**From:** [Julian Philcox](#)  
**To:** [Bob Neville](#)  
**Cc:** [Sarah Stevens](#); [Democracy](#)  
**Subject:** Hornton Grounds Quarry - application 20/02553/FUL  
**Date:** 09 December 2020 11:01:09  
**Attachments:** [image003.png](#)  
[image007.png](#)  
**Importance:** High

In advance of planning committee's meeting of Thursday 10<sup>th</sup> December and further to the report of officers I wanted to bring a few matters to your attention Bob. My client concurs with the report of officers and recommendations, save for the fact that some of the identified impacts will be compounded and made more severe by the points raised below, and that a 6<sup>th</sup> Reason for Refusal should reasonably be advanced regarding the impact on the amenity enjoyed by the residents of the 3no. dwellings at Hornton Grounds (the farmhouse, farm cottage and separate apartment) – discussed below.

Title: PROPOSED SITE LAYOUT

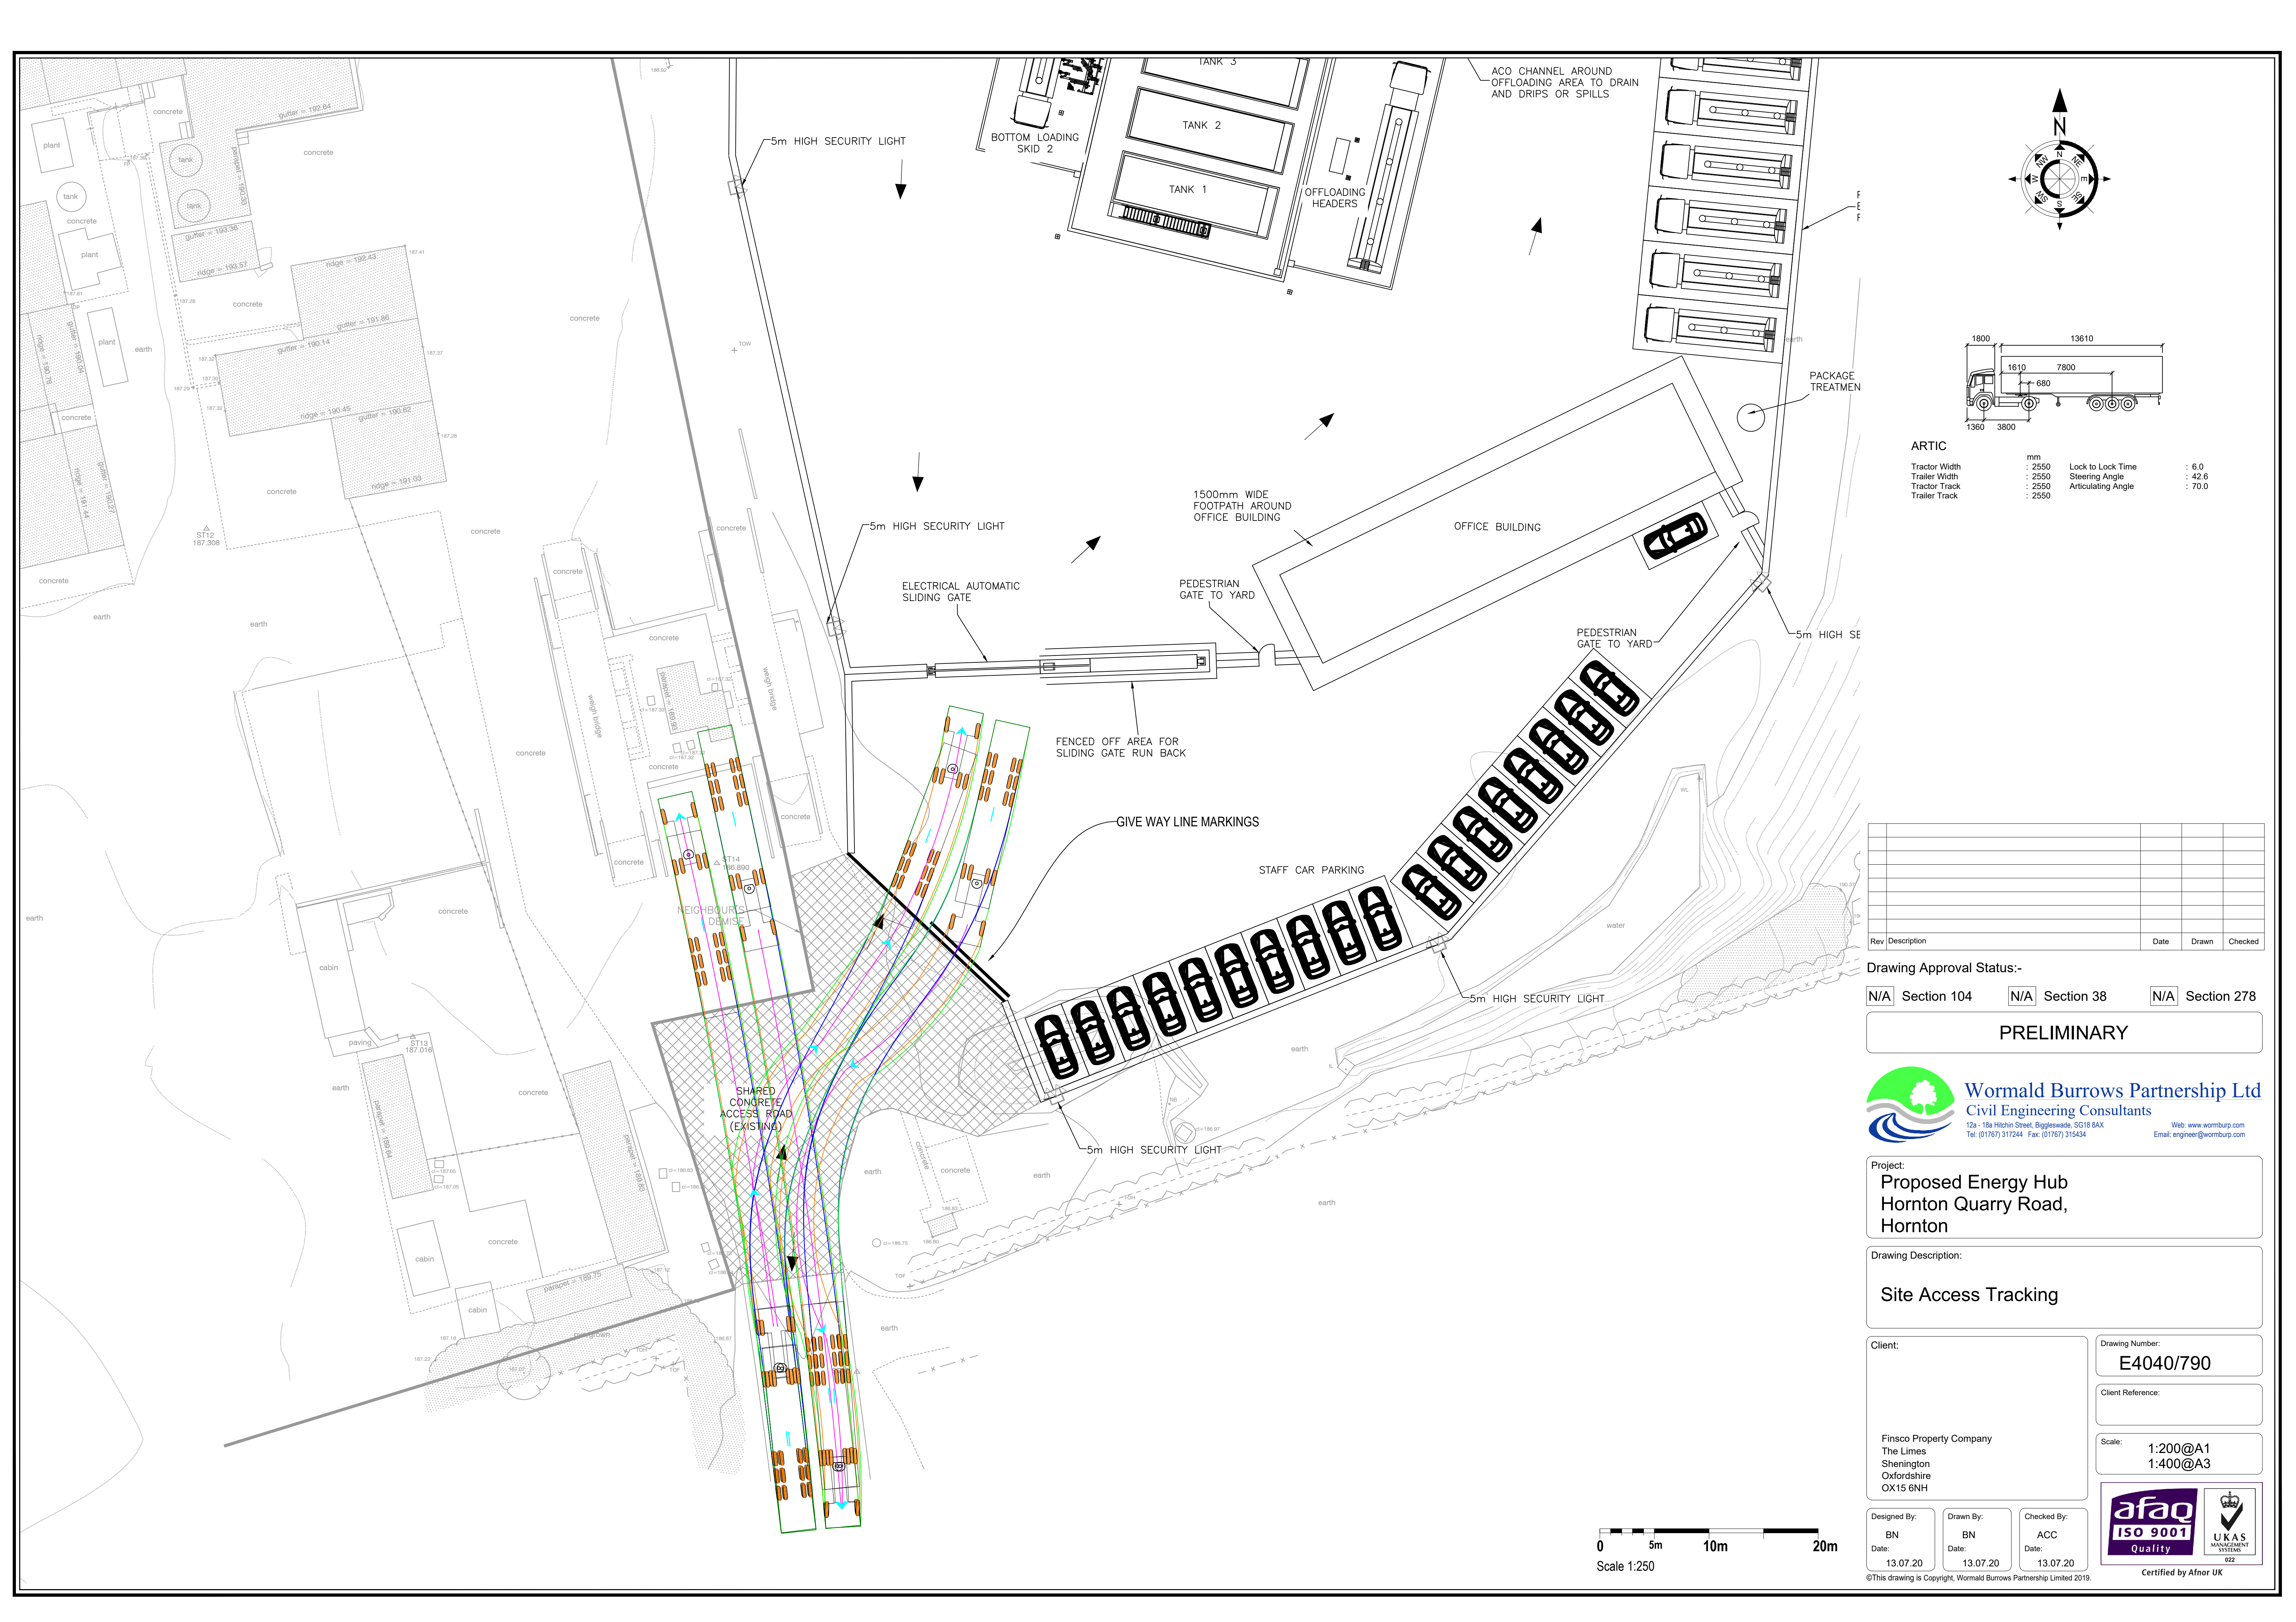
12. Aside from what is proposed, there is a concern that if approved the depot may grow. I had spotted on the proposed site plan that there is a **7th tank shown dotted** and annotated already, where currently 6no. 125,000 Litre tanks are proposed (so already growth is anticipated on top of Frampton's mentioned expansion over and above the existing CERTAS Banbury operation). All of the impacts above will be increased commensurately with the addition of a 7<sup>th</sup> tank, compounding identified impacts and harm.
13. The Transport Statement of CERTAS at Sugarswell and here at Hornton confirmed at paragraph 4.2.6 (in both cases) that :
